July 3, 2024

RE: Responses to Site Development Comments
Dutch Bros Coffee (CO0907)
5810 Omaha Boulevard, Colorado Springs, Colorado
City File No. PPR2413 / Our Job No. 23098

Cherokee Metro

Job Number	23098
Sheet	13
2019 DB	
Franchising USA, LLC

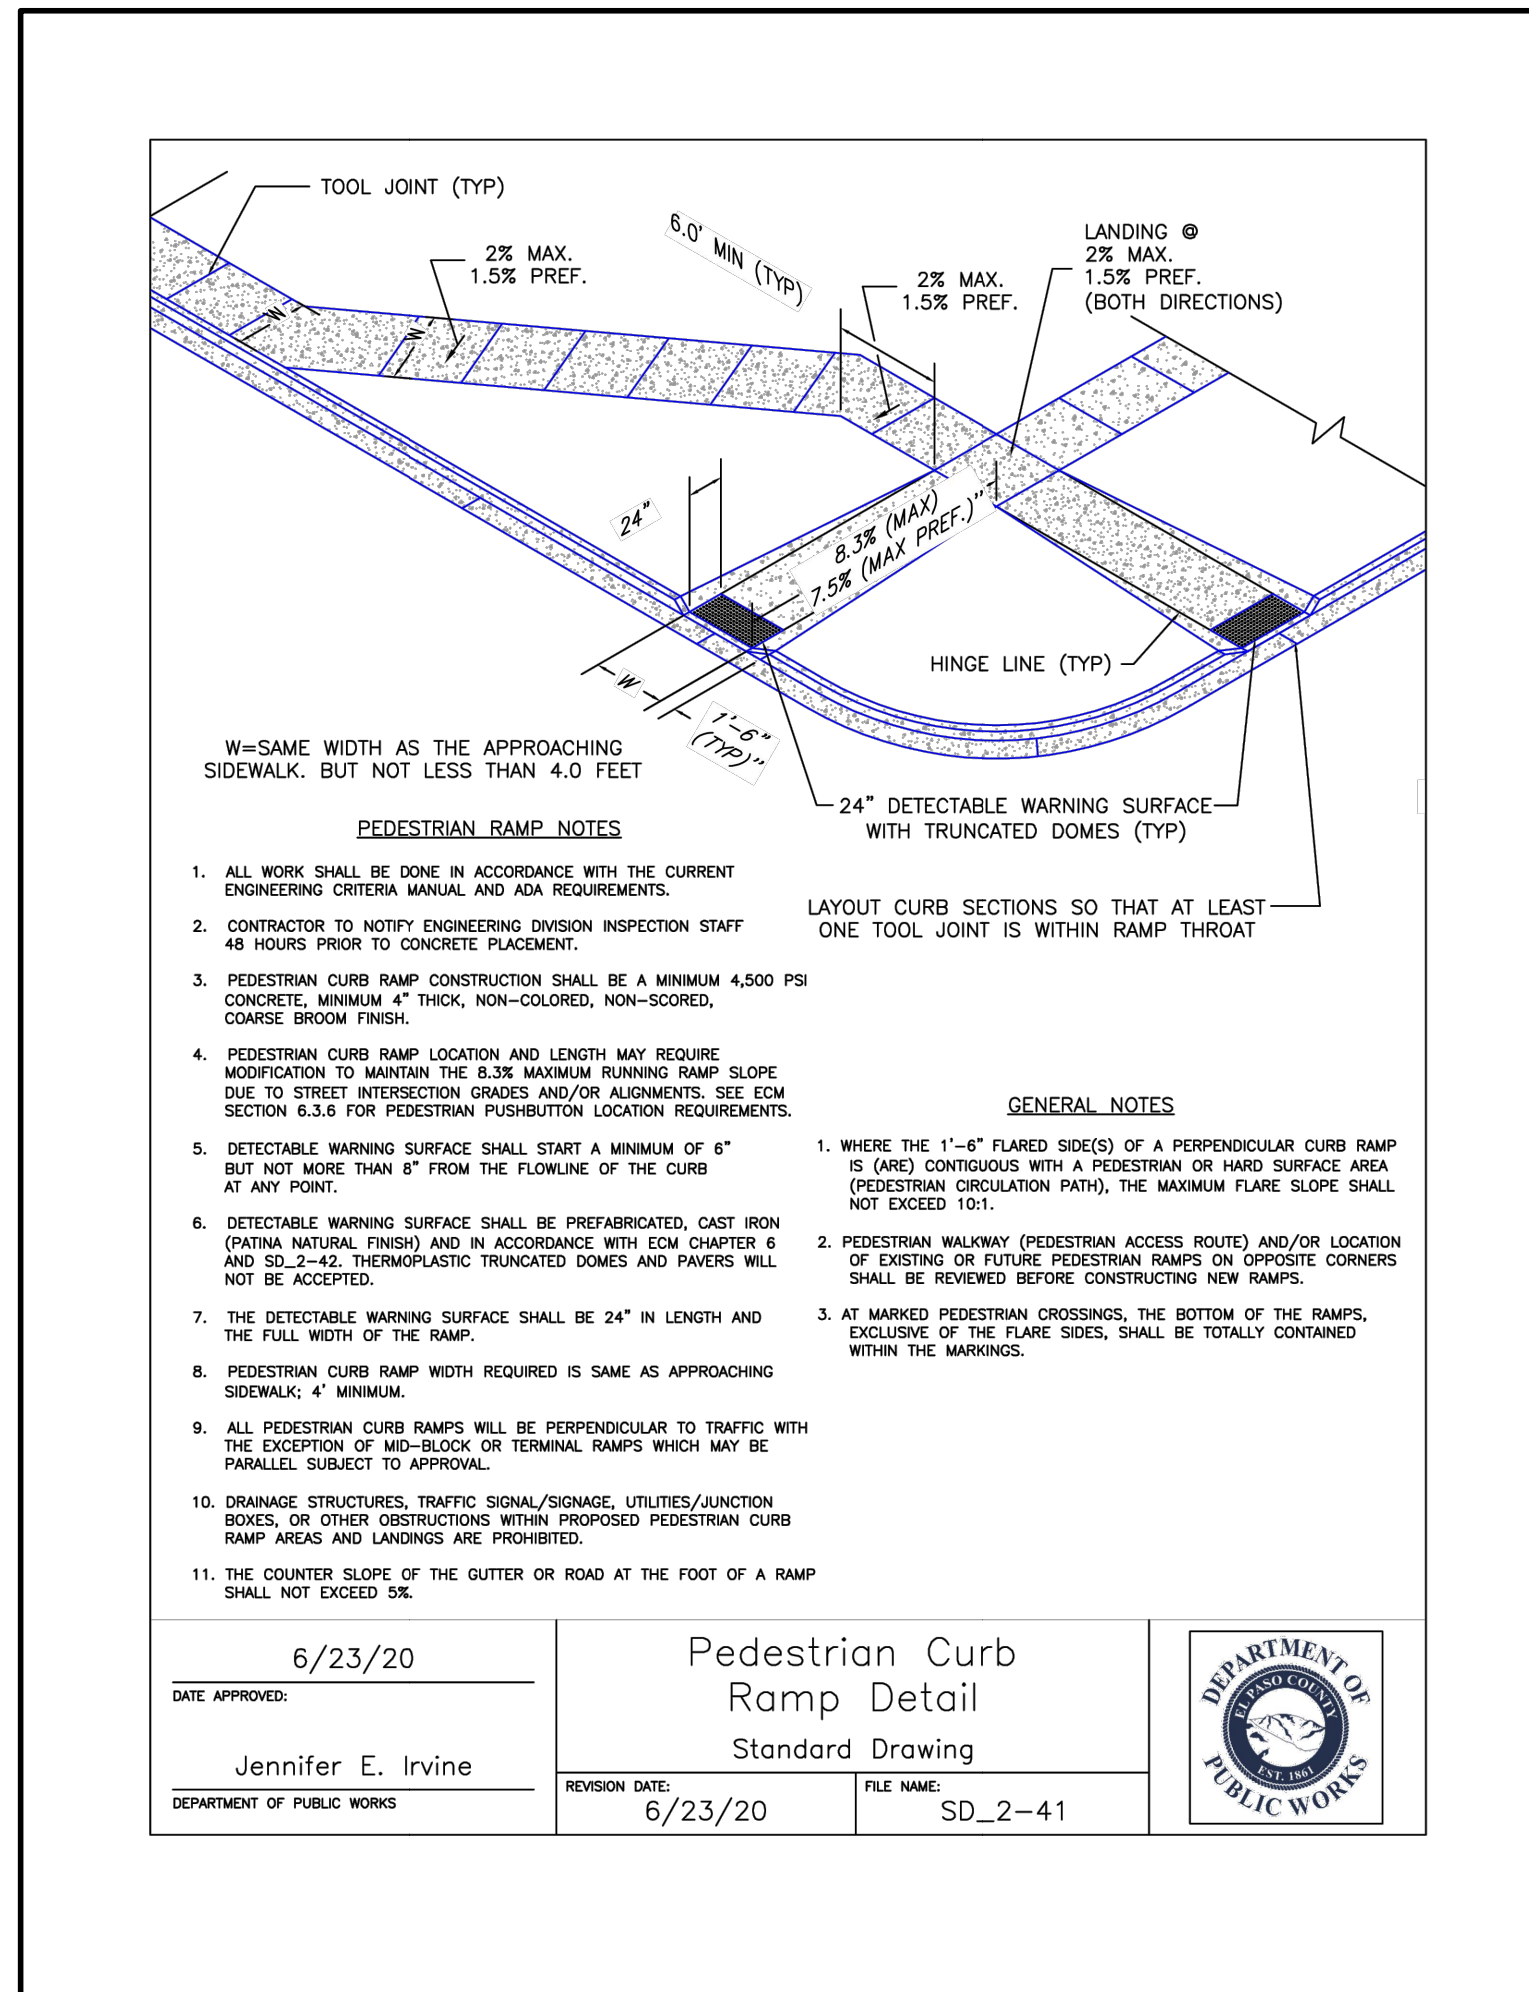
5. *The Grease interceptor needs to be a minimum of 325 gallons. Provide more detailed schematic*

9. *Grease interceptor needs to be a minimum of 325 GAL*

Response: The grease interceptor has been updated. The detail for the grease interceptor was added to the Detail Sheet 13.

Response: The grease interceptor has been updated. The detail is provided on Sheet 13.
